**WEST SUSSEX COUNTY COUNCIL
INFRASTRUCTURE CONSULTATION**

SUBJECT: BR/289/09- Application for Outline Planning Permission for conversion of existing house into 2no. flats. and erection of 2 no. new dwellings.

7, Nelson Road, Aldwick, Bognor Regis, PO21 2RY

Site Block Plan @ 1:500

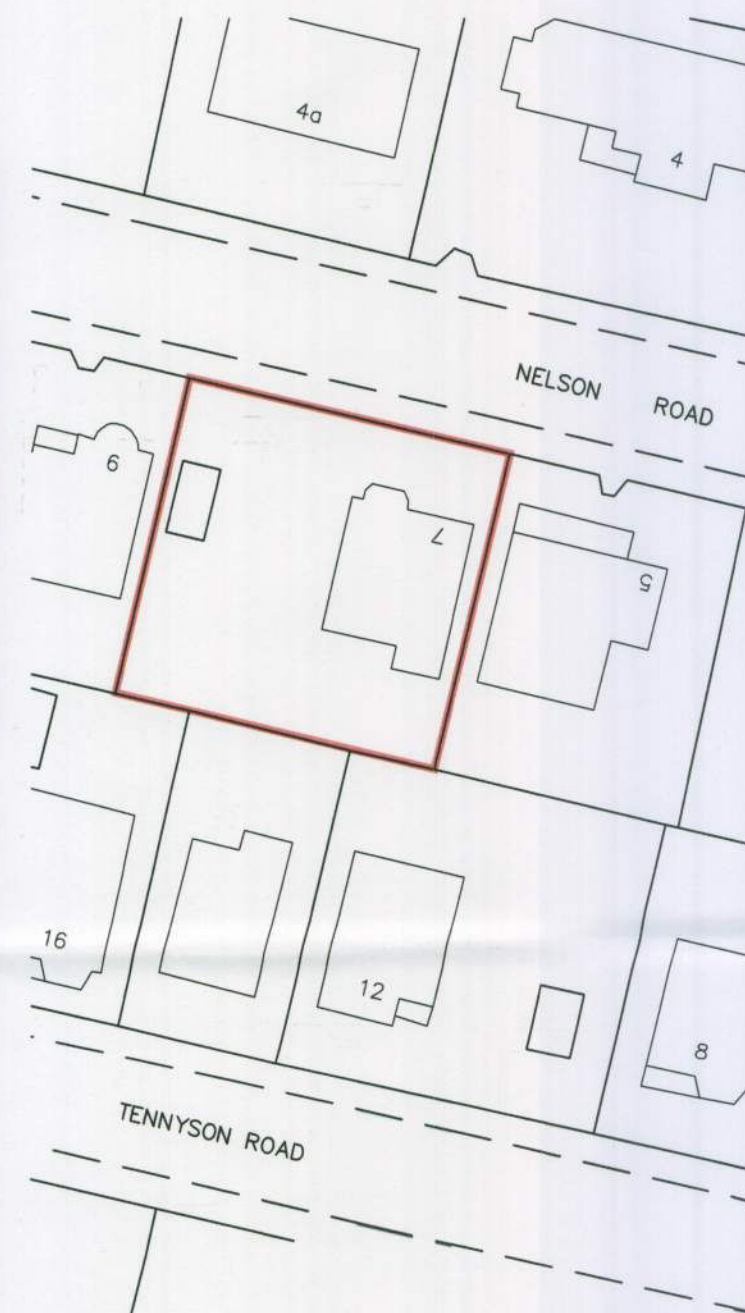
The proposed new dwellings will be served by new access points onto Nelson Road. Given the accesses are only serving one dwelling, a 3 metre wide access is considered sufficient for each properties needs. Any works on the highway must be agreed with the WSCC Local Engineer and carried out under licence. I would also require each driveway area and car parking spaces to be constructed in a bound material and that suitable drainage methods are installed to prevent private surface running onto the public highway.

The proposed car parking provision is within and does not exceed the WSCC Maximum standard. The site is located in an accessible location with Bognor Regis town centre and passenger transport facilities are within reasonable walking distance. With this taken into account cycle parking should be included; this must be secure, covered and be capable of storing at least one cycle per bedroom of the proposed dwelling. The actual details of the cycle parking facilities should be submitted to and approved by the Local Planning Authority (LPA). To accommodate cycle parking it would be recommended that any cycle store should have minimum dimensions of 2m x 1m.

As stated above off-street car parking is shown but there is no on-site turning space. From measuring the submitted plan, there is inadequate space to be able to provide this facility. This will inevitably result in vehicles reversing onto the public highway. However vehicular visibility along Nelson Road appears acceptable, with other properties having similar arrangements with apparent omission.

Nevertheless I would request that visibility splays for pedestrians are present at the new point of access onto Nelson Road. These should be 2 by 2 metres and should be kept free of all obstructions over 0.6 metres in height.

On the understanding that cycle parking is included and pedestrian visibility splays are provided, no significant concerns would be raised to this application.

If the LPA are minded to approve this application, a condition securing the new access, cycle parking and provision of pedestrian visibility splays prior to occupation of the dwellings should be included.
